SM ROCHA, LLC

May 7, 2025

RE: Retreat at PrairieRidge Filing 1 / Transportation Memorandum
El Paso County, Colorado
PCD File No. 257

BRIARGATE PARKWAY ROUNDABOUT
DETAILED GRADING PLAN

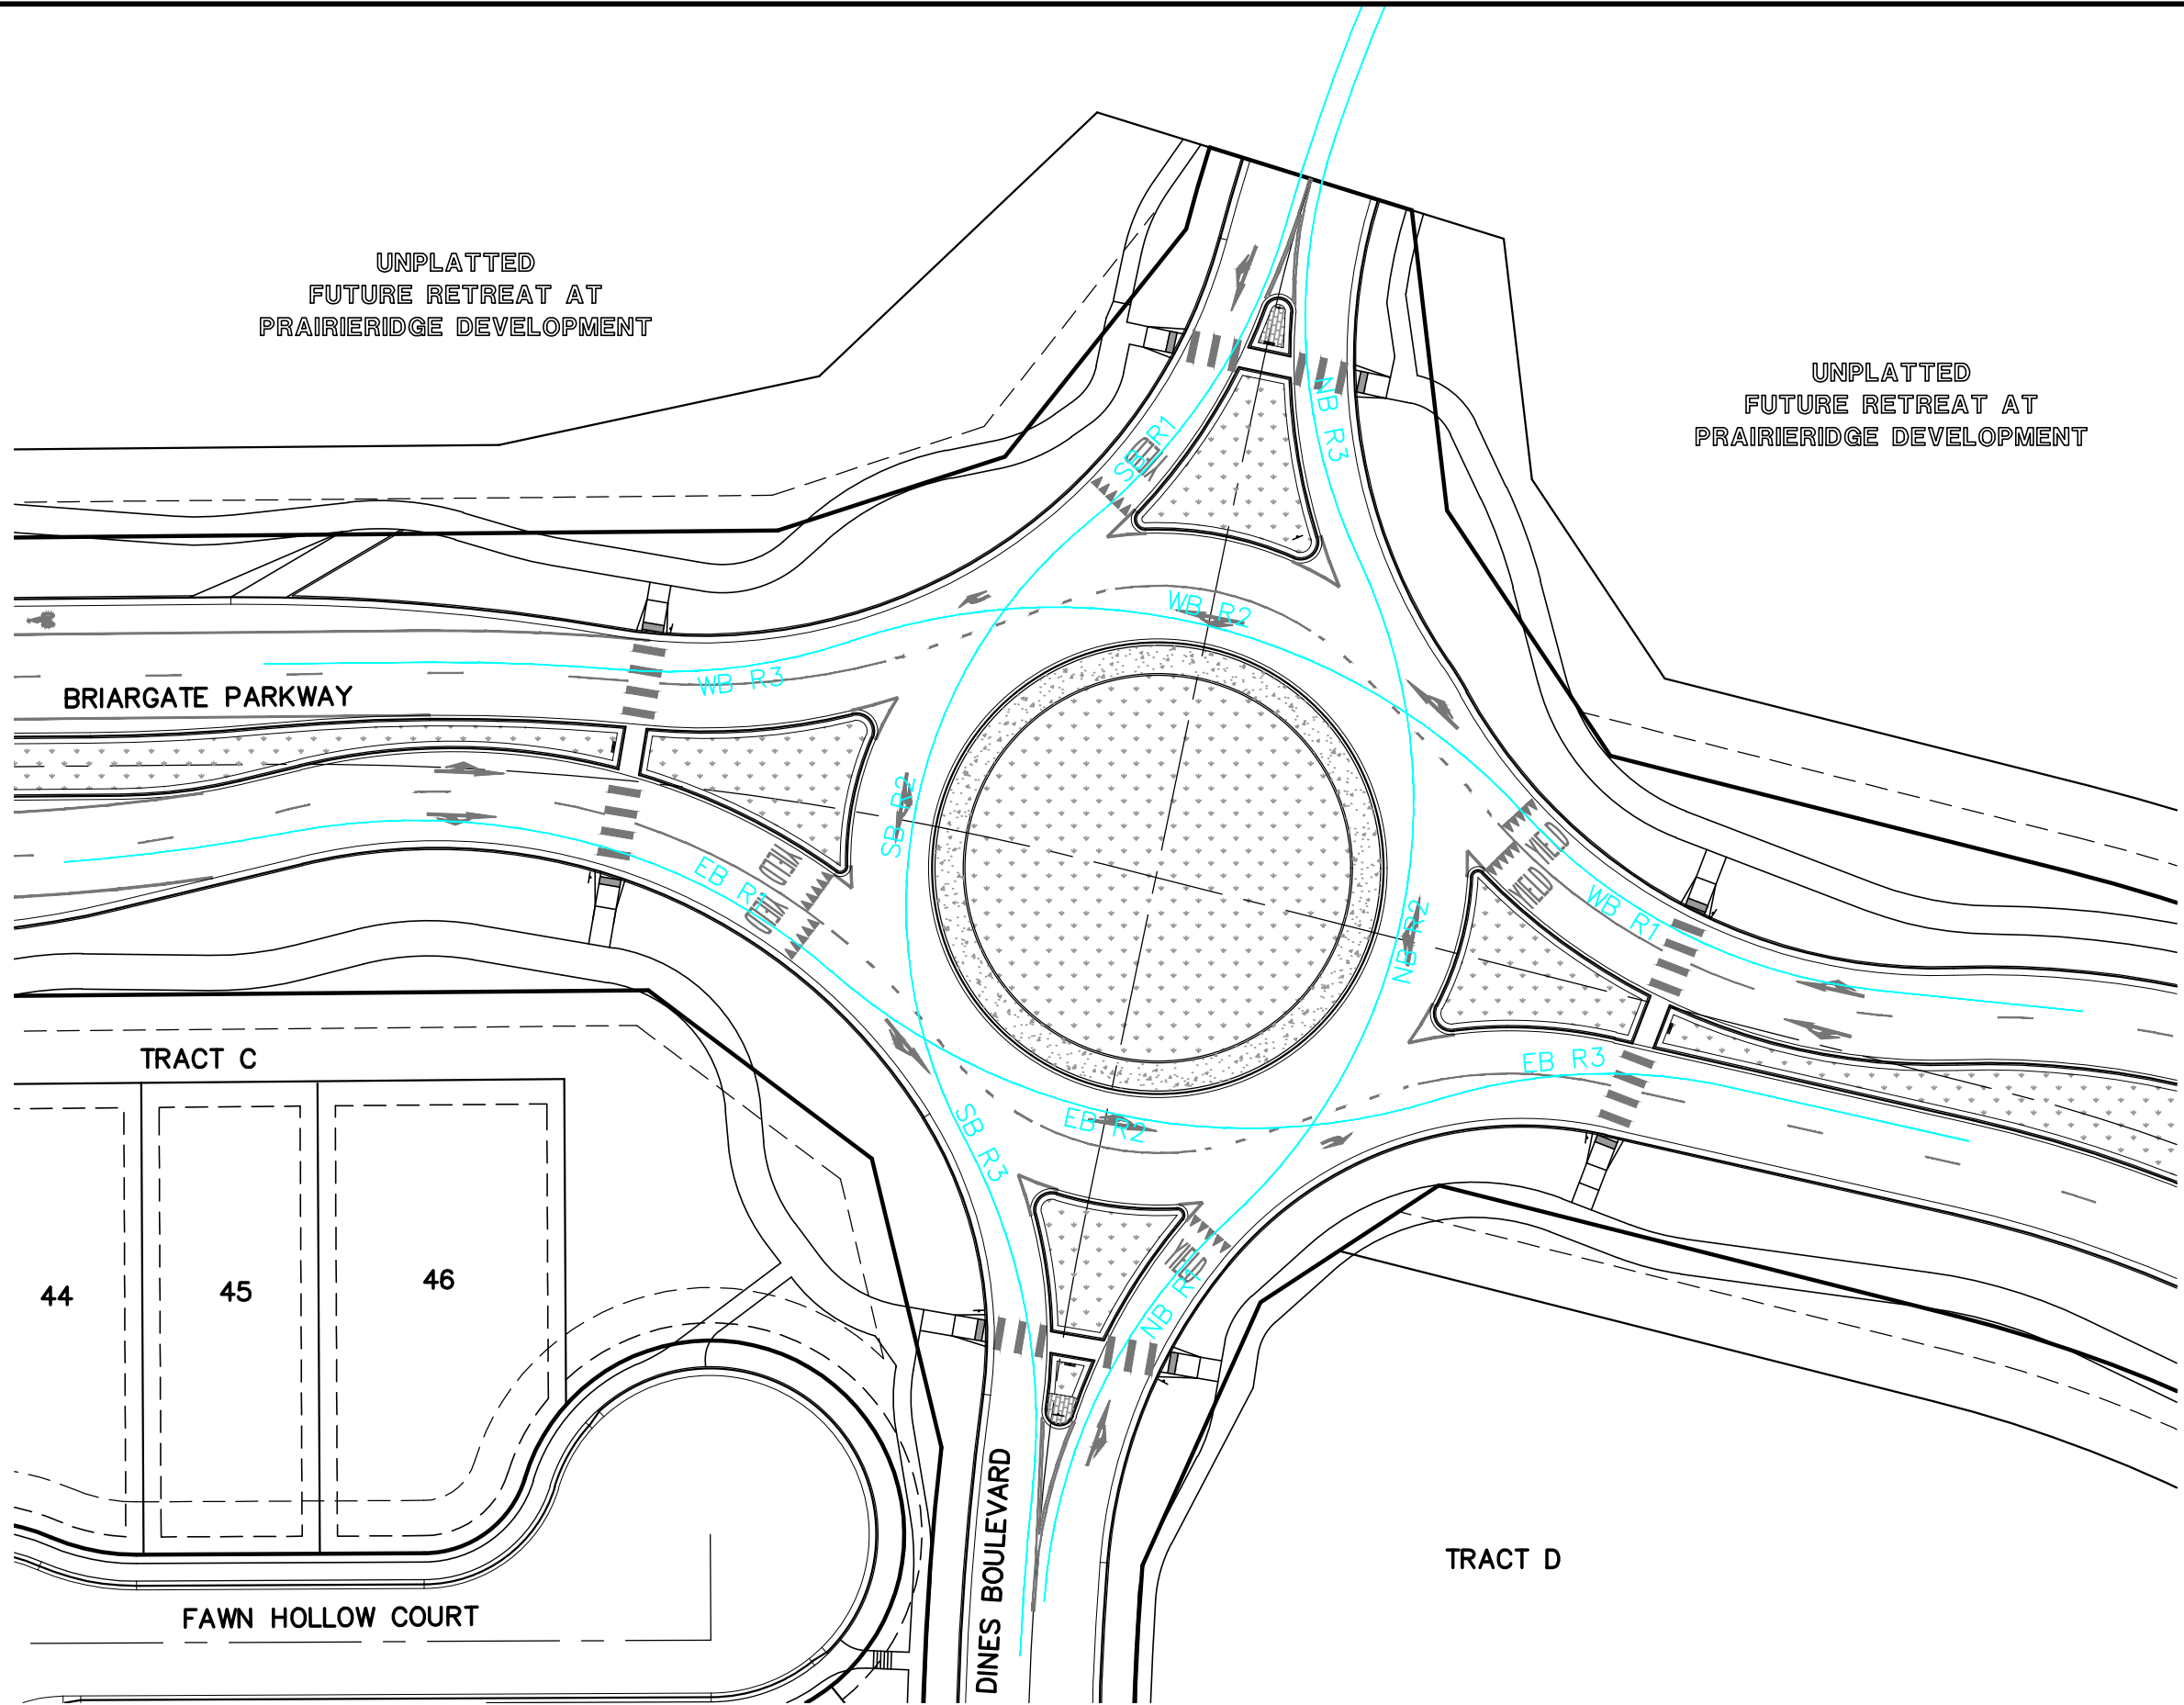
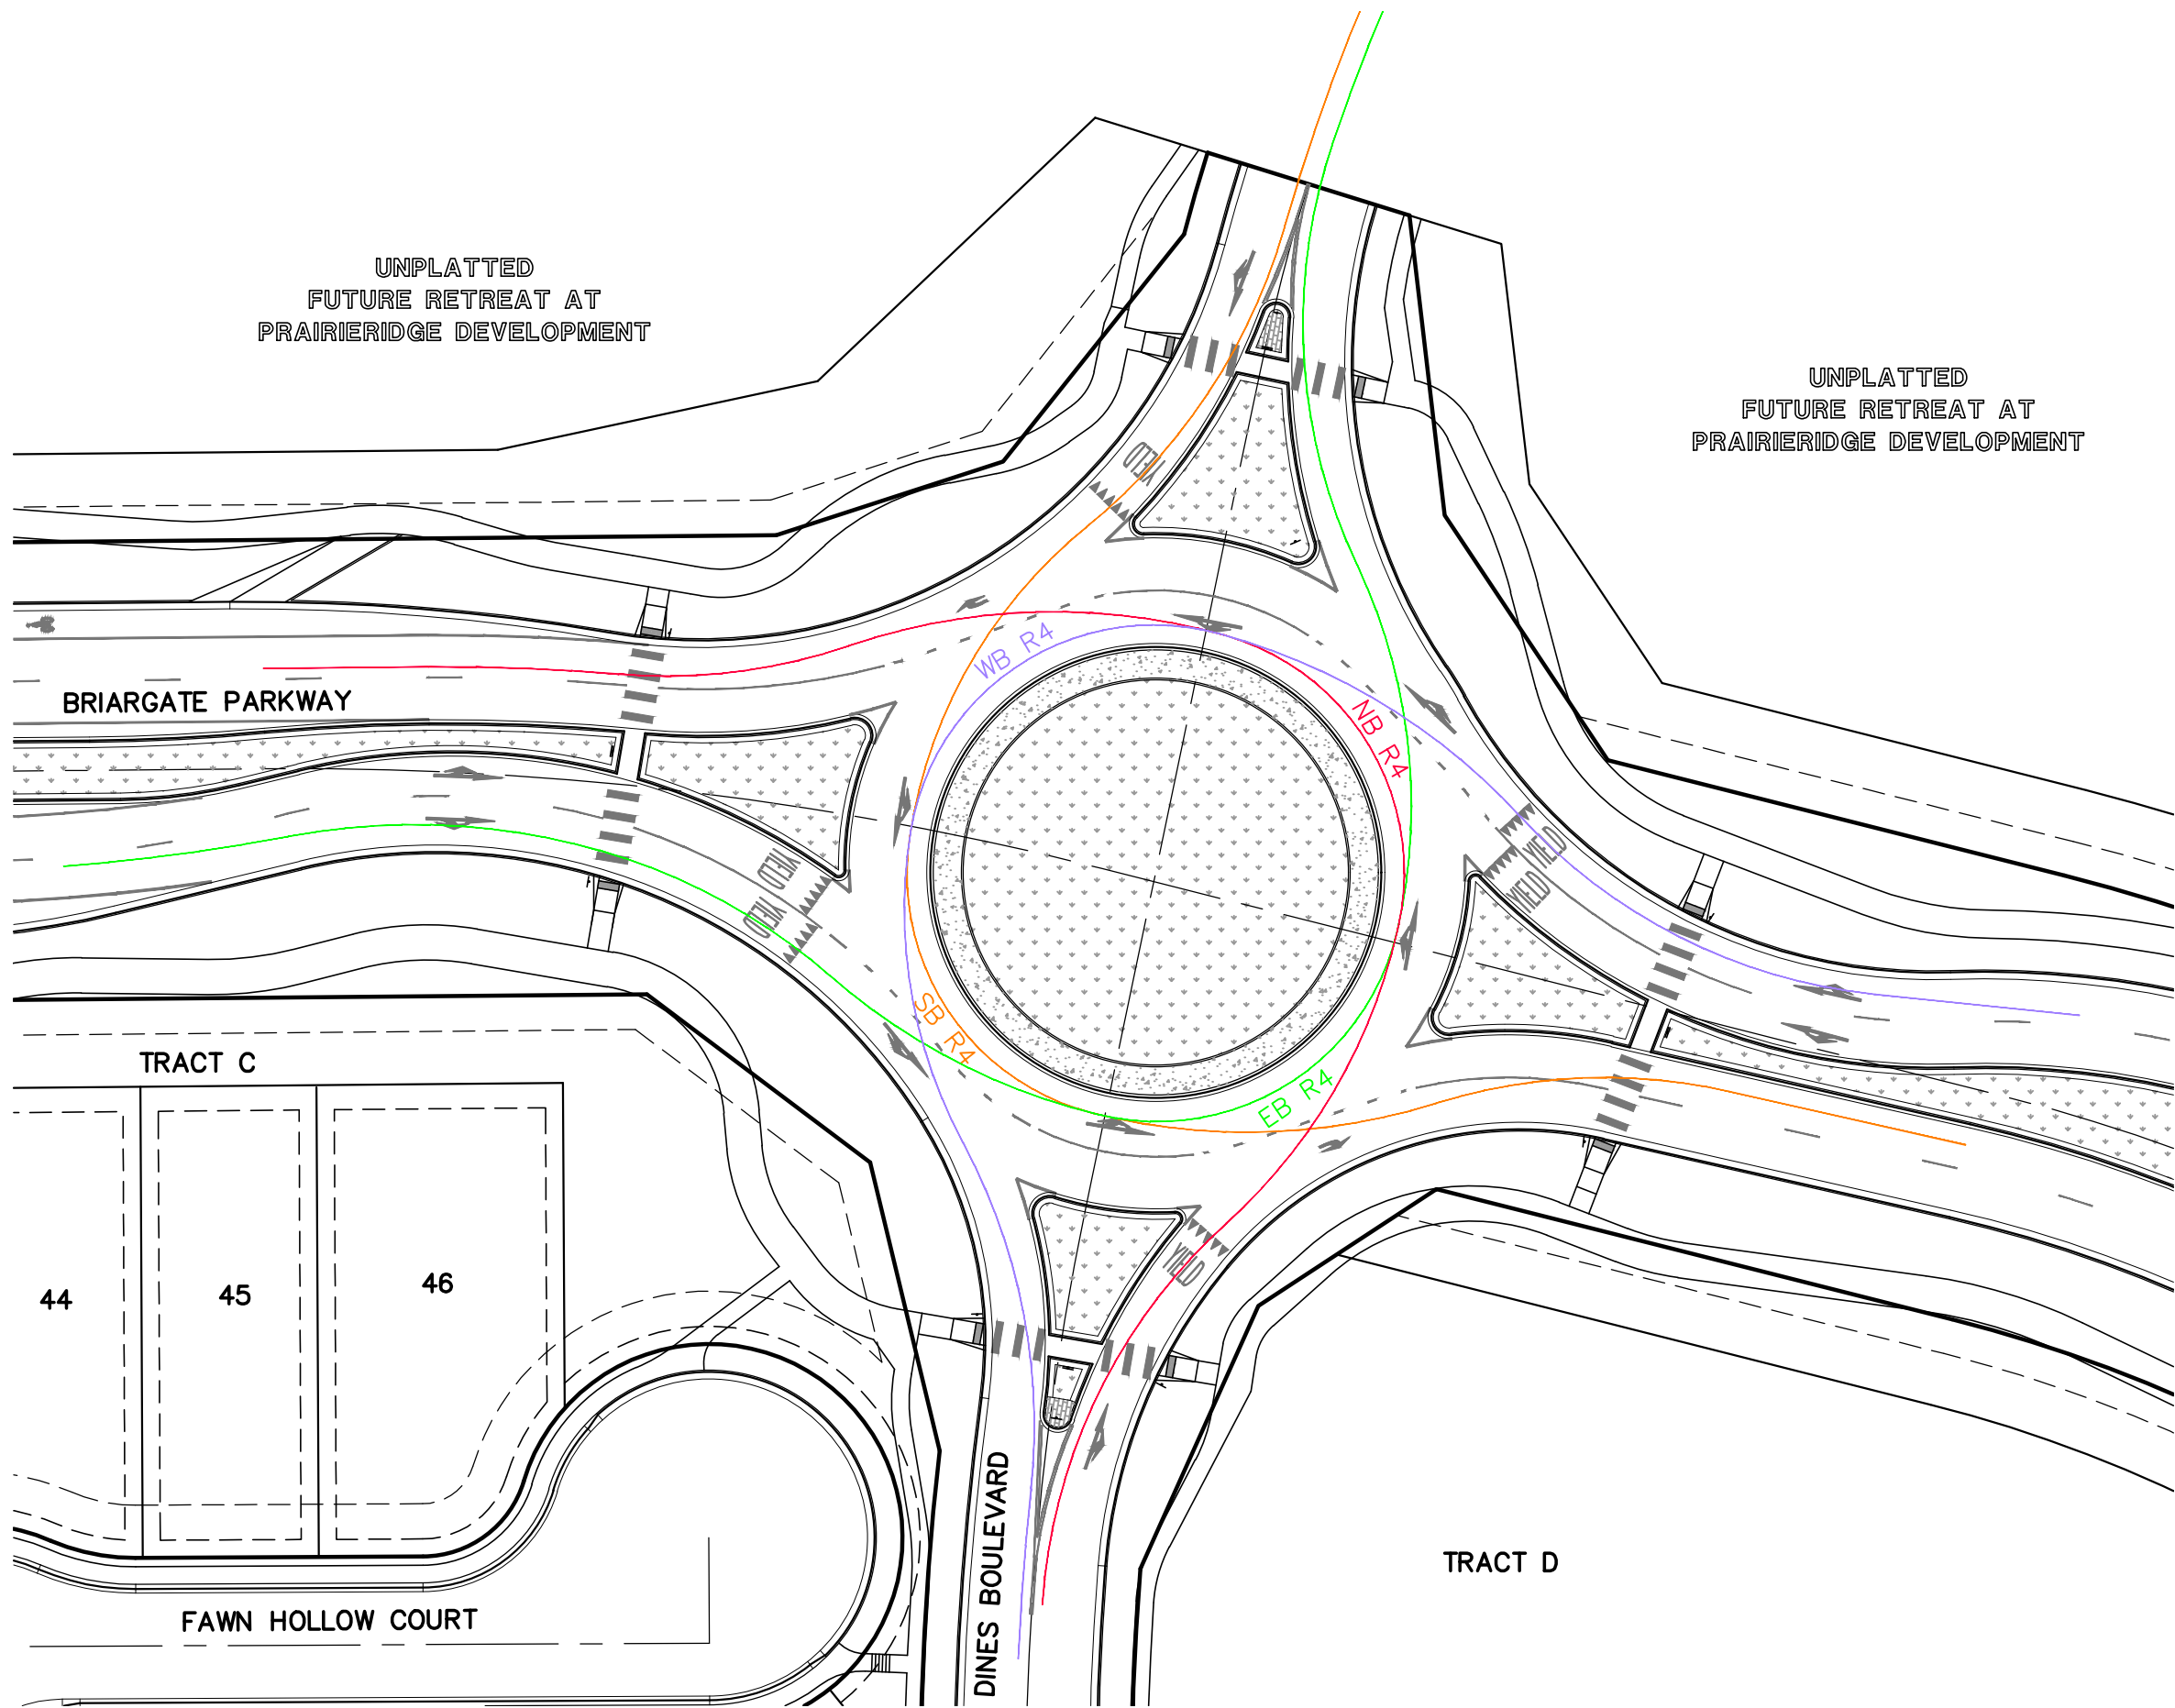
The future Briargate Parkway intersection with Dines Boulevard is recommended to operate under roundabout control. This recommendation is consistent with analyses provided within the Retreat at PrairieRidge Filings 1-3 Preliminary Plan & Rezones traffic study and the Jayne's Property – Roundabout Consideration memorandum⁷ previously prepared for the Briargate Parkway and Dines Boulevard intersection. [Unresolved: Please provide final roundabout design report, as mentioned in the preliminary plan TIS.](#)
